**Written representation by
First Corporate Shipping Limited
trading as The Bristol Port Company**

23 November 2020

**Application by North Somerset Council for an order granting development
consent for the Portishead branch line - MetroWest phase 1**

**Planning Inspectorate reference TR040011
Interested party reference PORT-S57657**

Drawn by: FG Date: 26/02/2018
Checked by: KW Date: 26/02/2018
Approved by: ADL Date: 26/02/2018
Drawing No. 674946.BJ.35.01-06
Revision I

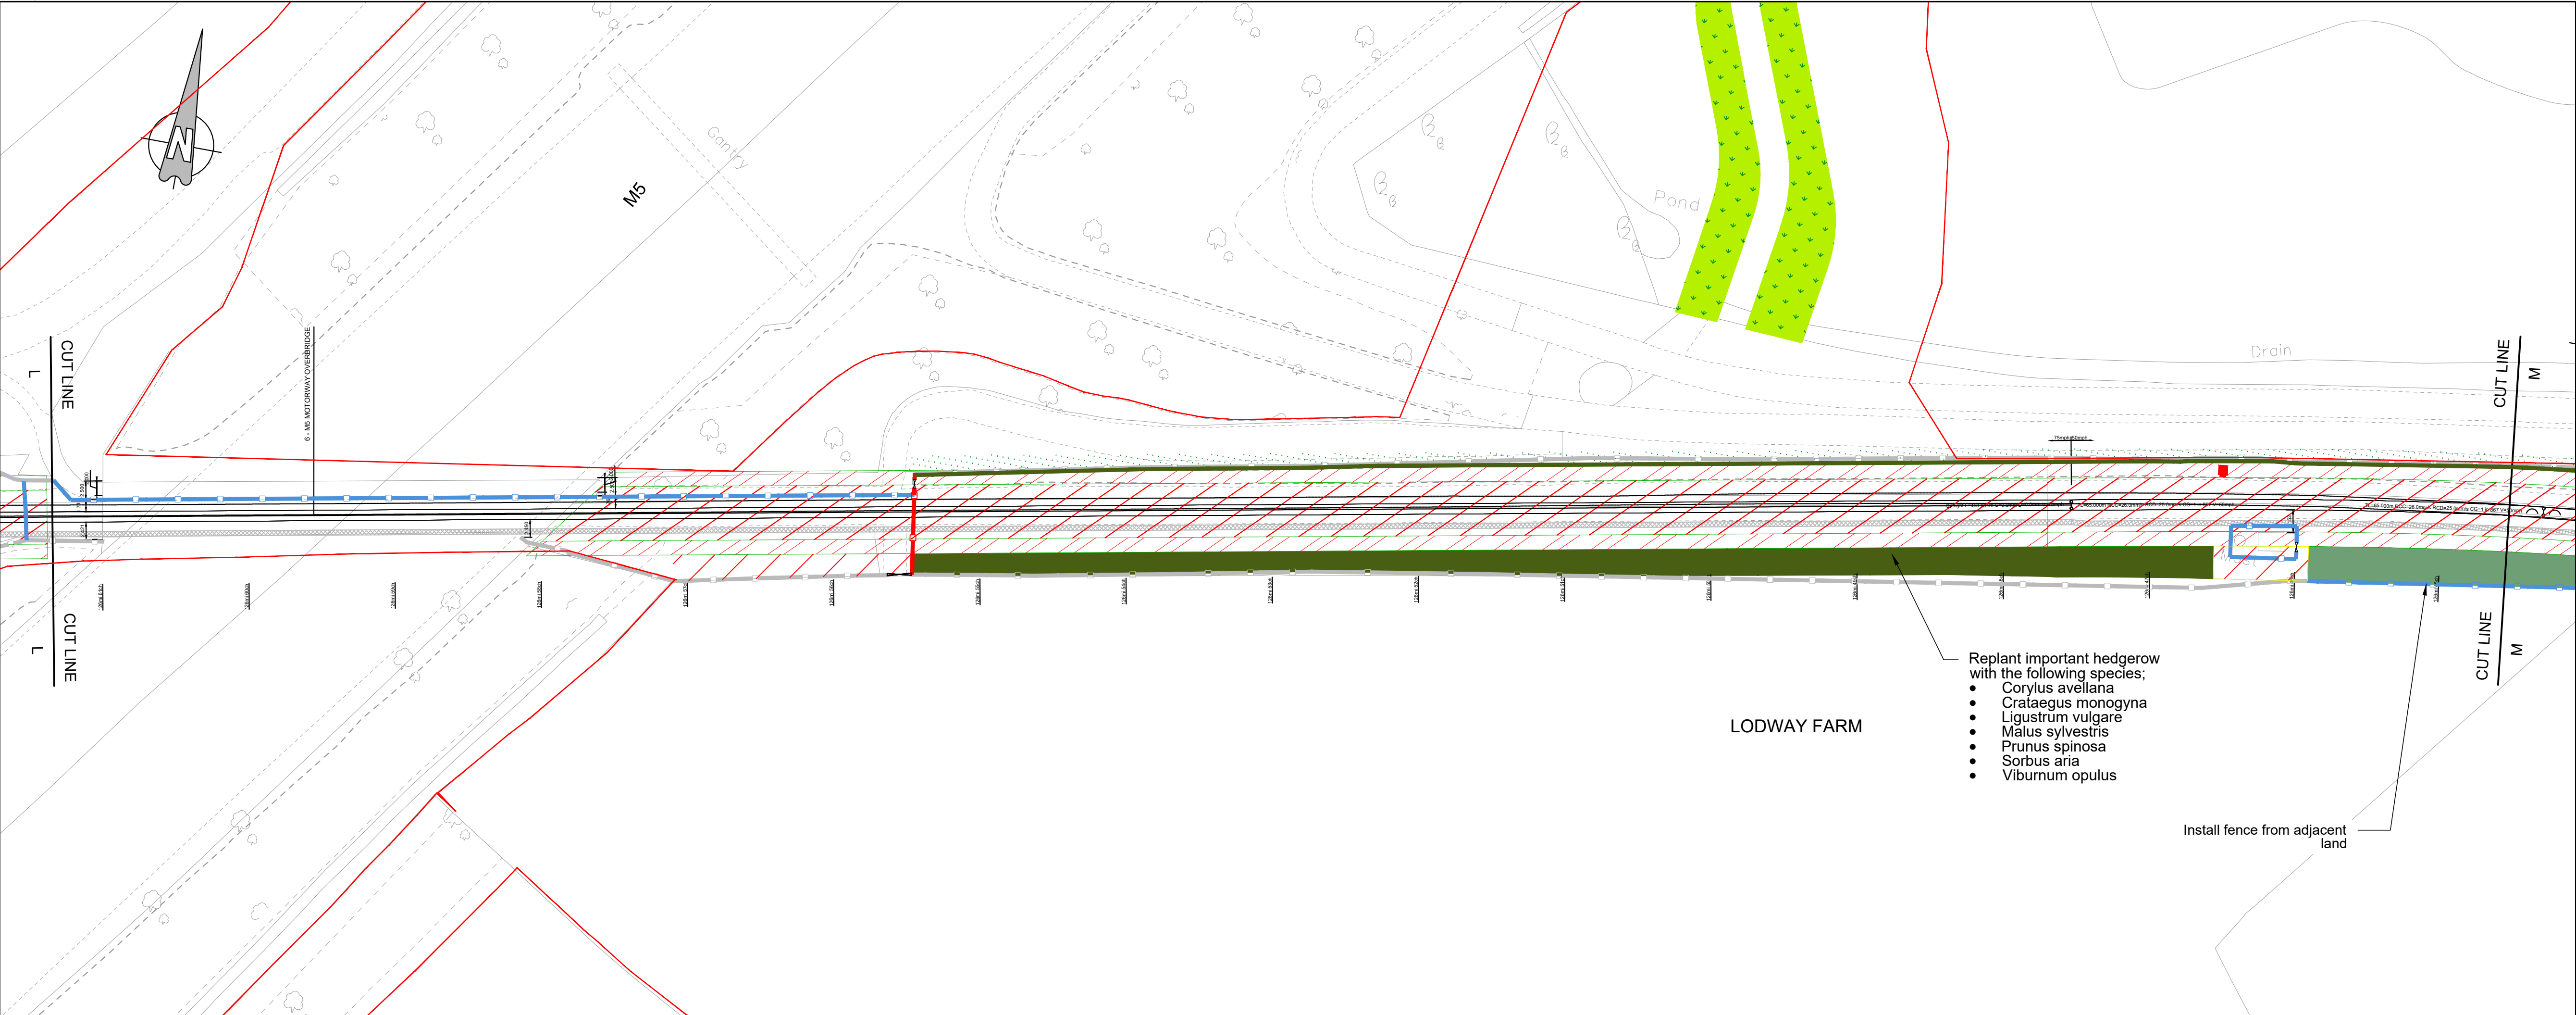
- 4.14 BPC also notes (from drawing 674946.BJ.35.01-06 Rev H in the Railway Landscape Plans (Disused Line) (document 2.10)) that new tree planting is proposed on its land forming part of temporary possession plot 05/28 between the Port perimeter track and the railway. BPC objects to this proposed planting because of the damage that could be caused to the track by the roots of the trees.
